January 31, 2024

RE: SF Final Plat – Falcon Meadows at Bent Grass Filing No. 3 - Drainage

# V\_7 Drainage Report - redlines.pdf Markup Summary

### Pond (North-Existing)

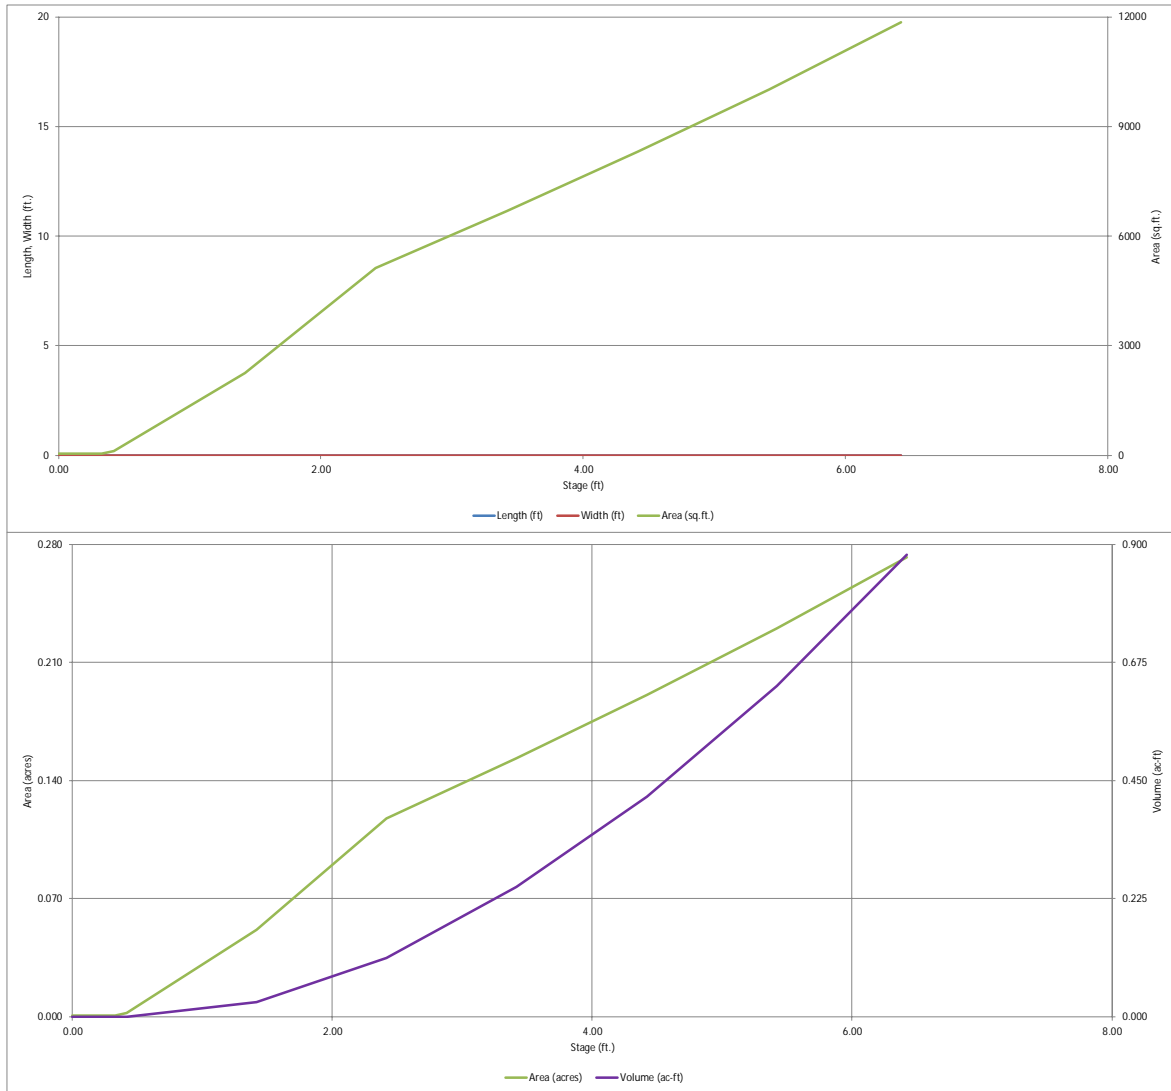
Please clarify this statement as the % impervious within this basin was 68.2% in the previously approved report and an additional lot has added. It does not make sense that the %impervious would decrease. Feel free to give me a call to discuss (719)-208-6783

Please clarify this statement as the % impervious within this basin was 68.2% in the previously approved report and an additional lot has added. It does not make sense that the %impervious would decrease. Feel free to give me a call to discuss (719)-208-6783

With the inclusion of the additional lot within sub-basin C-1c, the % imperviousness has been reduced from 77.5% (FDR) to 41.4%
